Application for a non-material amendment following a grant of planning permission.

House name: CLYTHA

Address 1: YAPTON ROAD

REAR SINGLE STORY EXTENSION. 5.5 x 5 m
WITH REPLICA ROOF

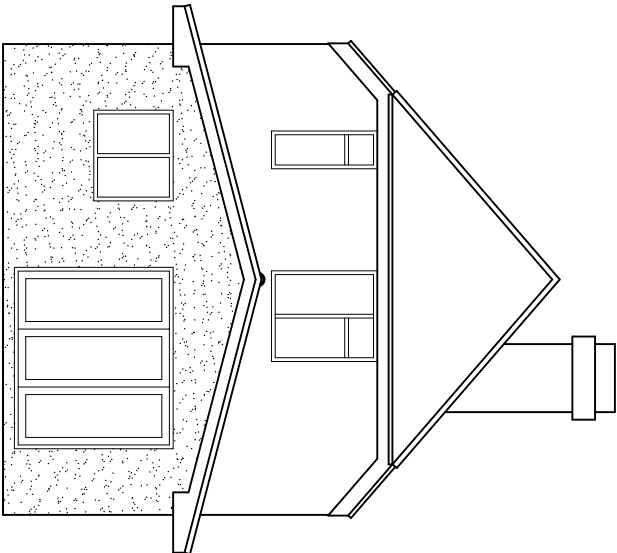
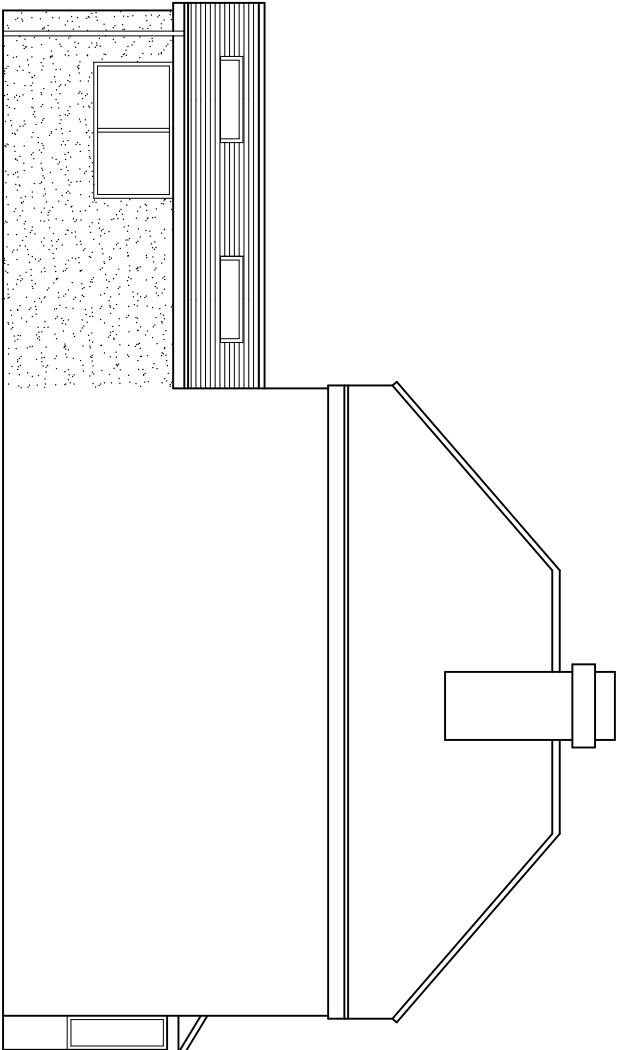
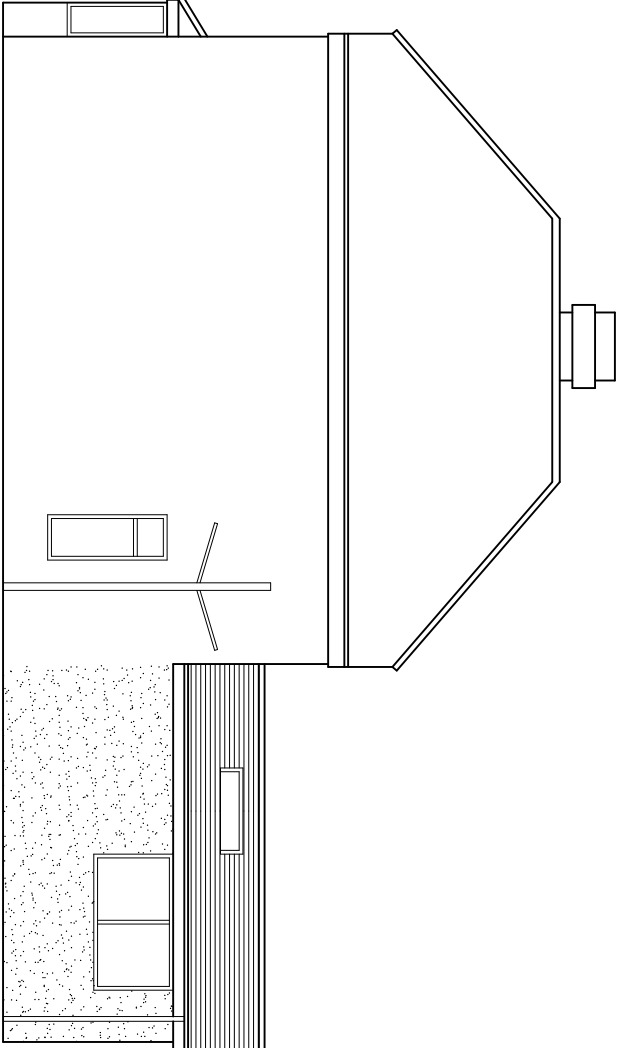
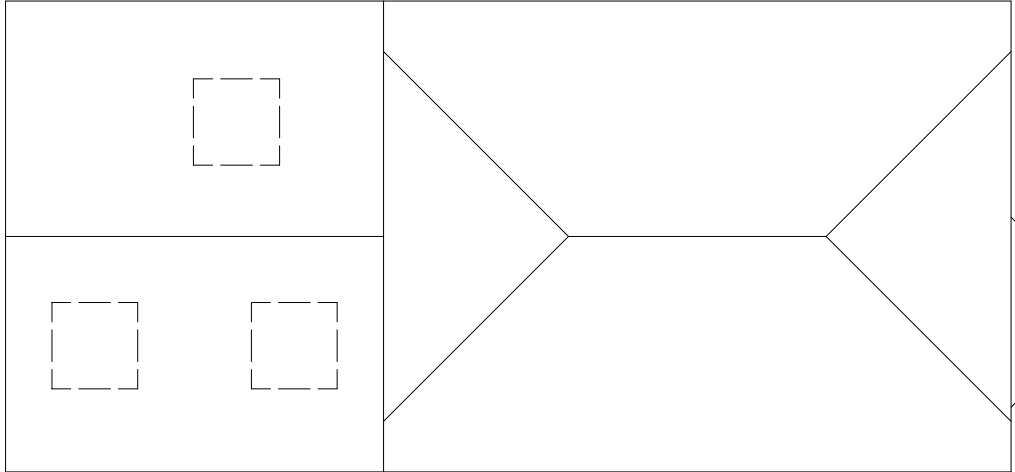
- ① TO EXTEND TO WIDTH OF HOUSE APPROX FROM 5.5 TO 6-metres x 5 metres LONG
- ② REPLACE REPLICA ROOF WITH TILED ROOF
- ③ NO side window on left HAND SIDE

THE EXTENSION SHOULD HAVE BEEN SUBMITTED AS full width of HOUSE. NOT DONE BY ANGELIAN. AND DO NOT WANT A REPLICA CONSERVATORY TYPE ROOF.
